Chamisa Cove Subdivision Sidewalk Culvert Revision

City Project # 656081

Re: Chamisa Cove Subdivision Drainage Report

Engineer's Stamp dated 8-18-00 (H11/D61)

CITY OF ALBUQUERQUE PUBLIC WORKS DEPARTMENT ENGINEERING GROUP			
CHAMISA COVE GRADING & DRAINAGE PLAN			
Design Review Committee	City Engineer Approval	Mo./Day/Yr.	Mo./Day/Yr.
City Project No.	Zone Map No.	Sheet	Of
H11/D61	H-11-Z	1	1

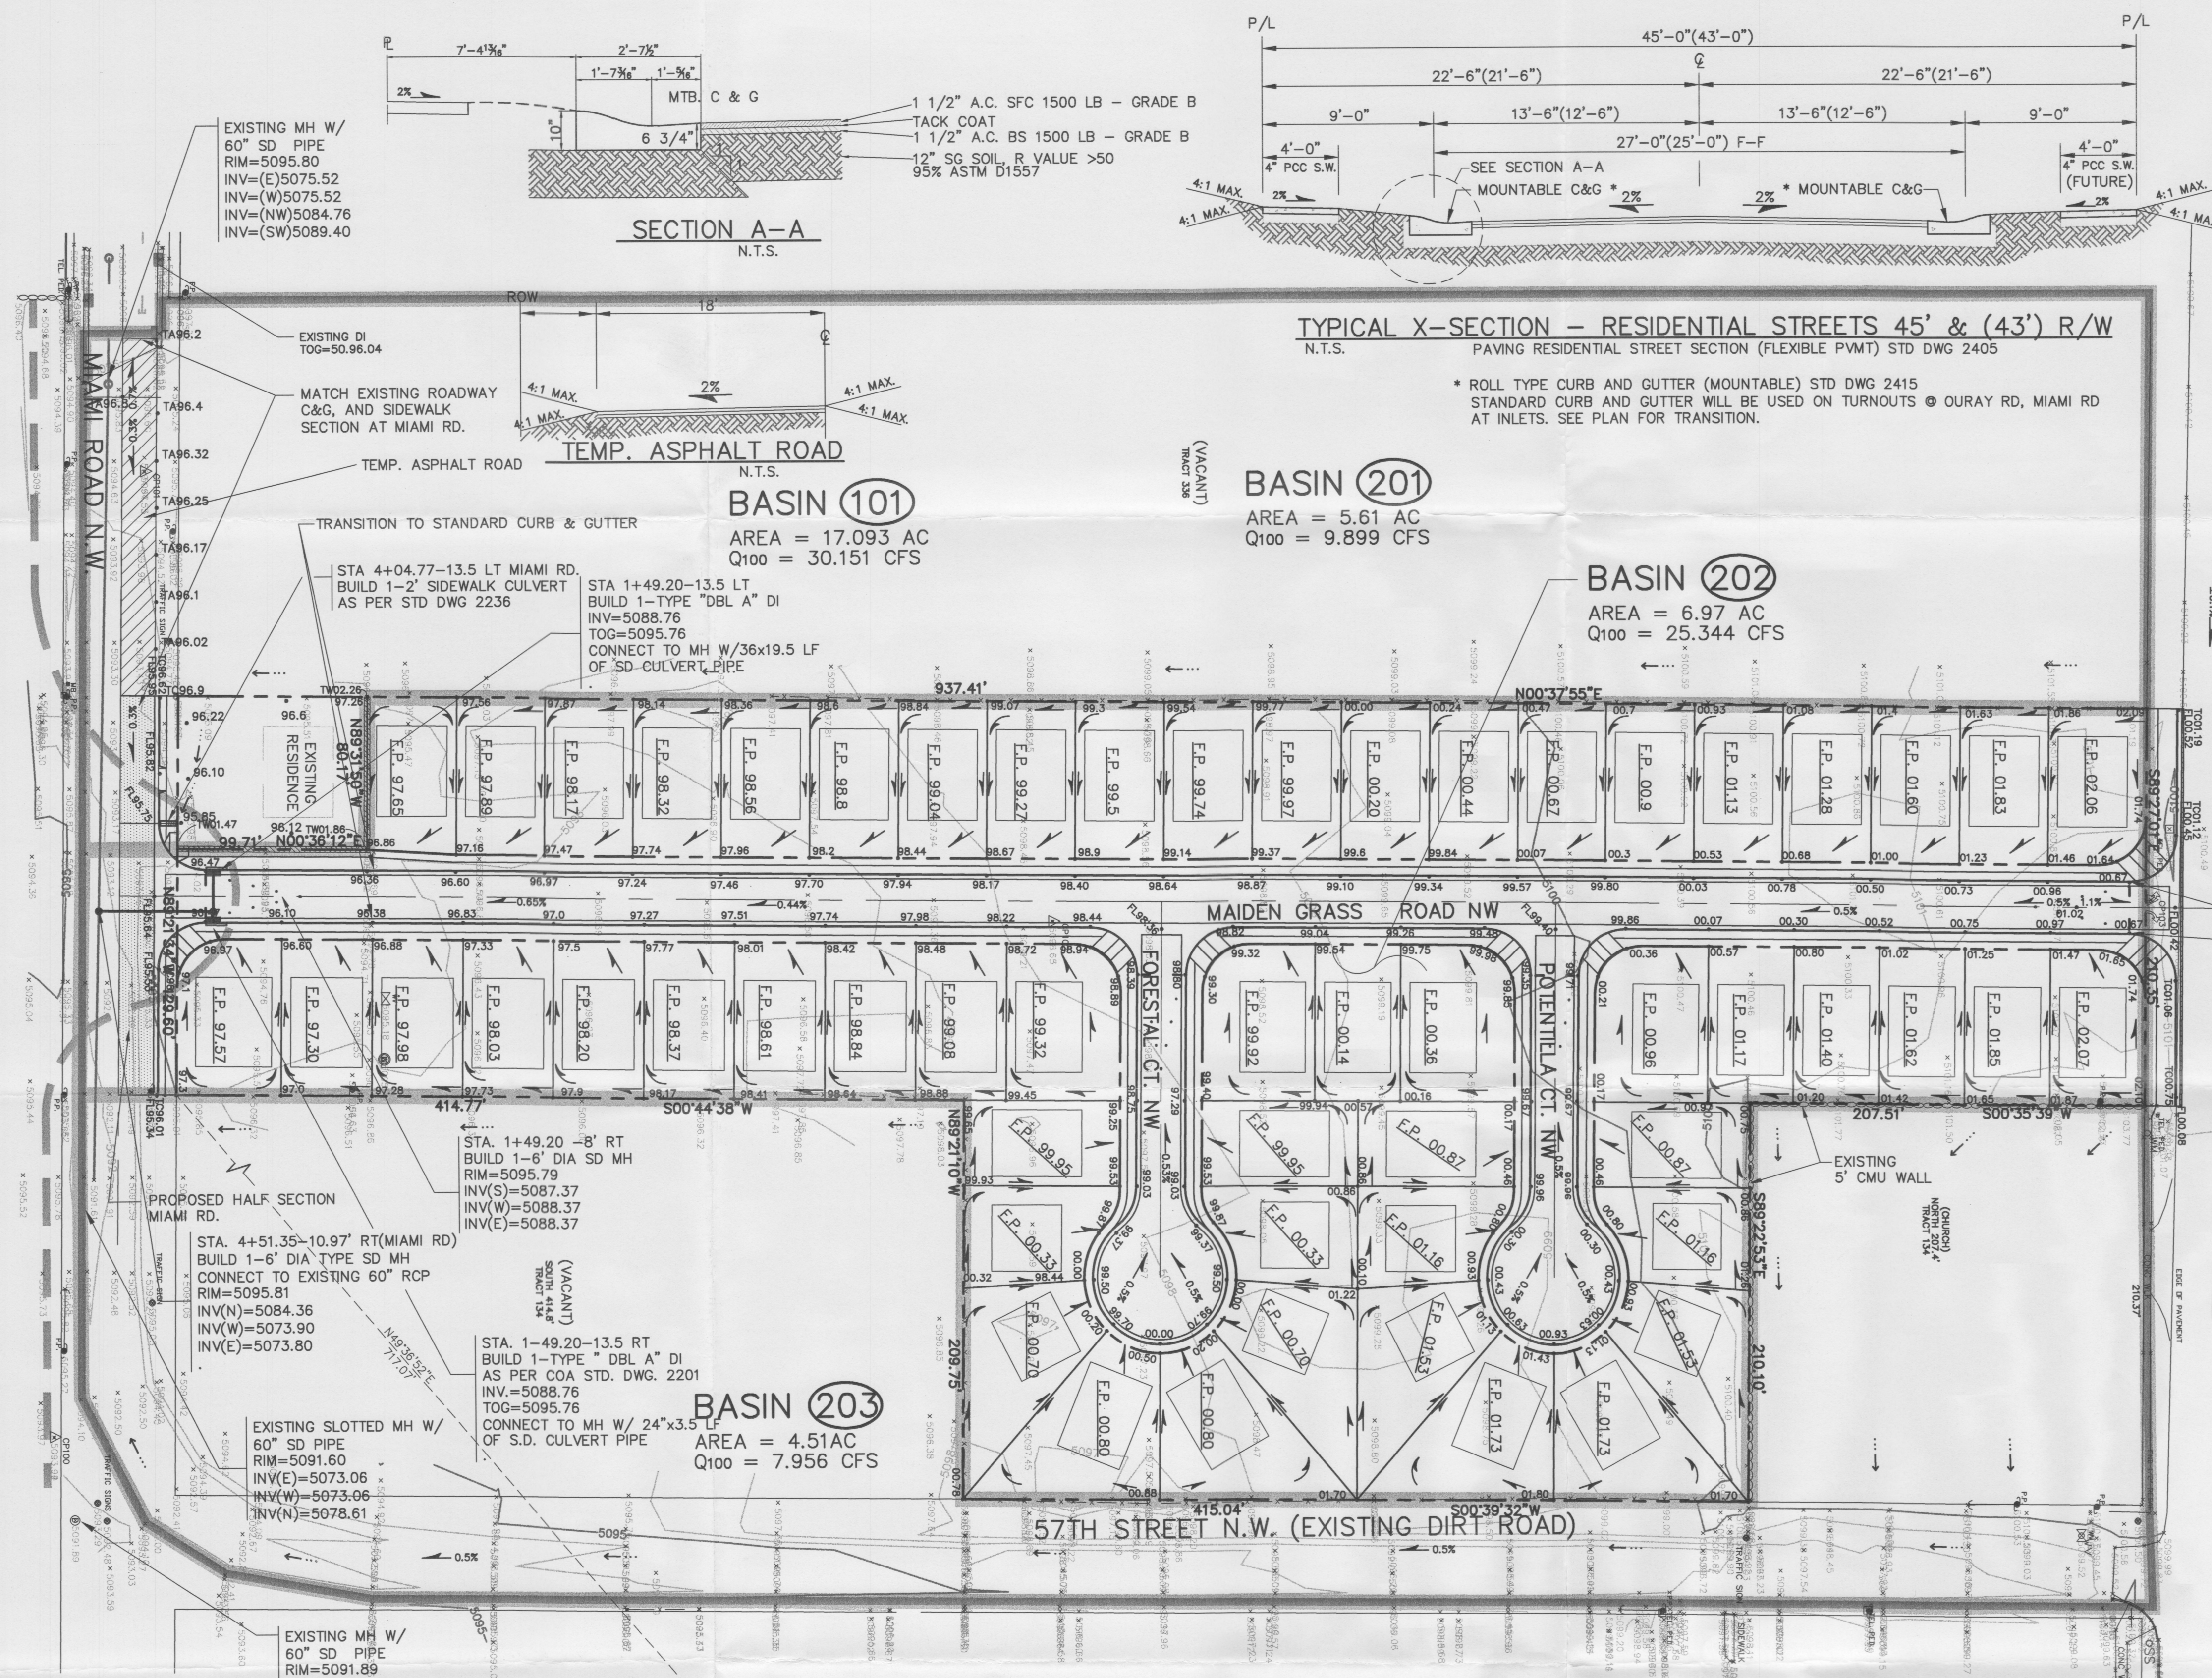
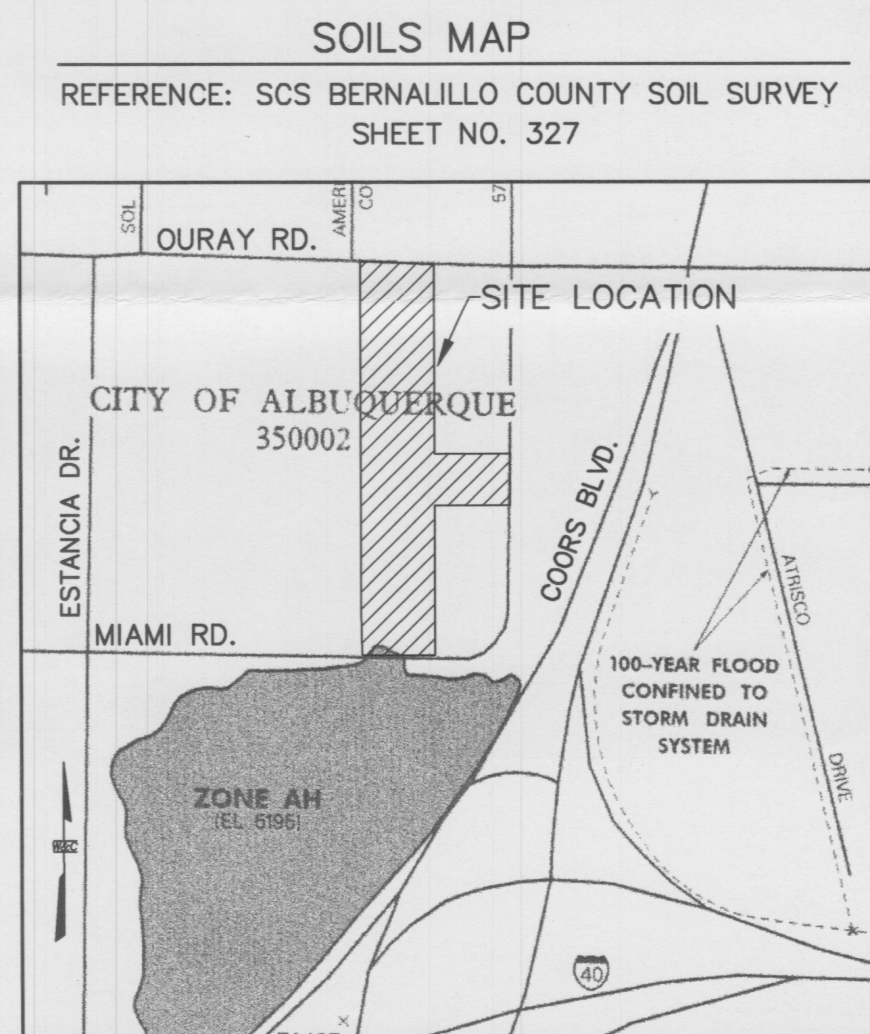
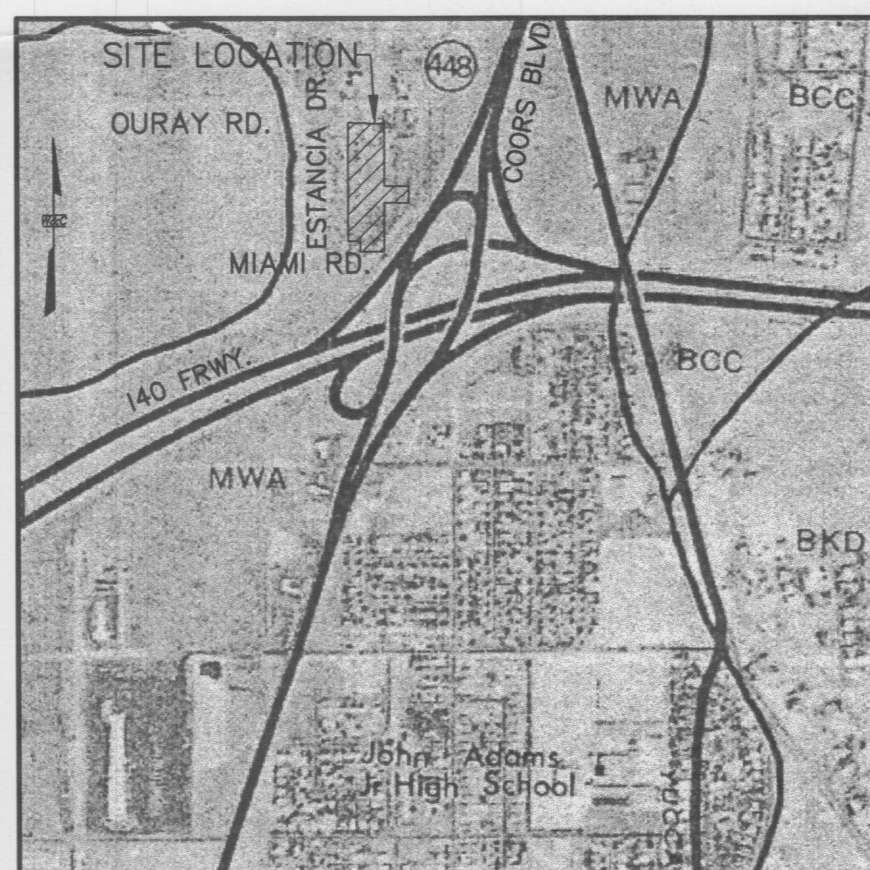
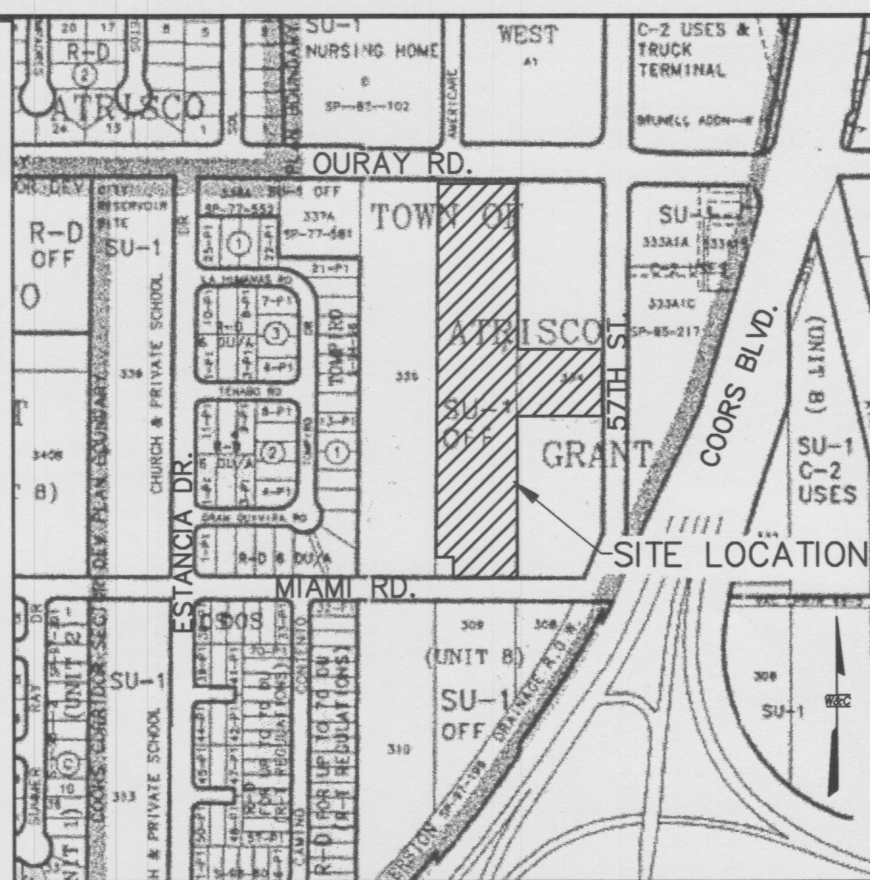
- Inlets 15' deep are costly and not advisable for this plan. Please make them shallower.
- The difference in elevation of the right-of-way above the flowline of roll curb is 0.51 feet. You will need to adjust all ROW grades accordingly.

- Please show the limits of the floodplain on the grading plan. I am not sure how you determine that the floodplain, which is a zone AH (usually considered a ponding area), is contained in the street, especially if the street isn't built yet. Be advised that the base elevation of 5195 shown on the FIRM map is incorrect (it should be 5095). Regardless, abutting finish floor elevations must be 1 foot above this. Therefore, the finish floor elevation of lot 21 should be 5096 at a minimum.

- What is the mean elevation of your benchmark?
- You will need to provide spot elevations and road grades on both Ouray and Miami and profiles as well. Please indicate what part of these roads are existing and what is proposed.

- You will need a water block on Street 'A' to keep runoff in Ouray from entering your subdivision.
- You show no contours for Basin 201. How can I be sure how this drains? It appears that a retaining wall will be needed on the west side of this subdivision. Also, how does the church parcel drain and are you cutting off the flow path? From the information provided in the appendix, it is supposed to drain to the south. Without contours or mention in the report, I can't tell.
- Please provide the Preliminary plat and Infrastructure List for comment.

- The drop inlets located on the southern end of the site have been resized to be approximately 7 ft. deep. The reason for the depth is due to clear zone between the storm drain and sanitary sewer.

- The difference in elevation between the property line and top of curb is 0.5 feet. The required minimum elevation is 0.48 ft.
- The limits of the floodplain have been added to grading and drainage sheet. Lot 21 finish pad elevation is 5097.51 ft. The base elevation, shown on the FIRM map panel 327, Zone AH is 5095 ft. The flood ponding is 2.57 ft below the finish pad elevation of lot 21. The future construction of the West Bluff Channel will determine the new flood designation for the area.

- The mean elevation of the benchmark used in the survey is as follows: Control Station 11-H11 with an elevation (SLD 1929) 5098.514 feet. See grading and drainage sheet.

- Existing Spot elevations for Ouray Rd., including proposed top of curb elevations at the tie in, and proposed spot elevations at the proposed roadway of Miami Rd. are included on the grading and drainage plan. Plan and profile sheets for the proposed roadway of Miami Rd. will be included in the plan set, as required by DRC submittal.

- A water block is at the intersection of Maiden Grass Rd. and Ouray Rd. to prevent runoff from entering the subdivision. See grading and drainage sheet.

- Existing spot elevations are included on the grading and drainage plan approximately 25ft. west of our property line to show tract 336 existing flow patterns. There will be no wall needed on the west side of the subdivision. A wall will be included on the southern part of the subdivision separating an existing residence and the subdivision, see grading and drainage sheet for location. Tract 336 directly drains south onto Miami Rd. There will be no runoff entering our site from Tract 336. The existing church on the northeast end of the site currently drains
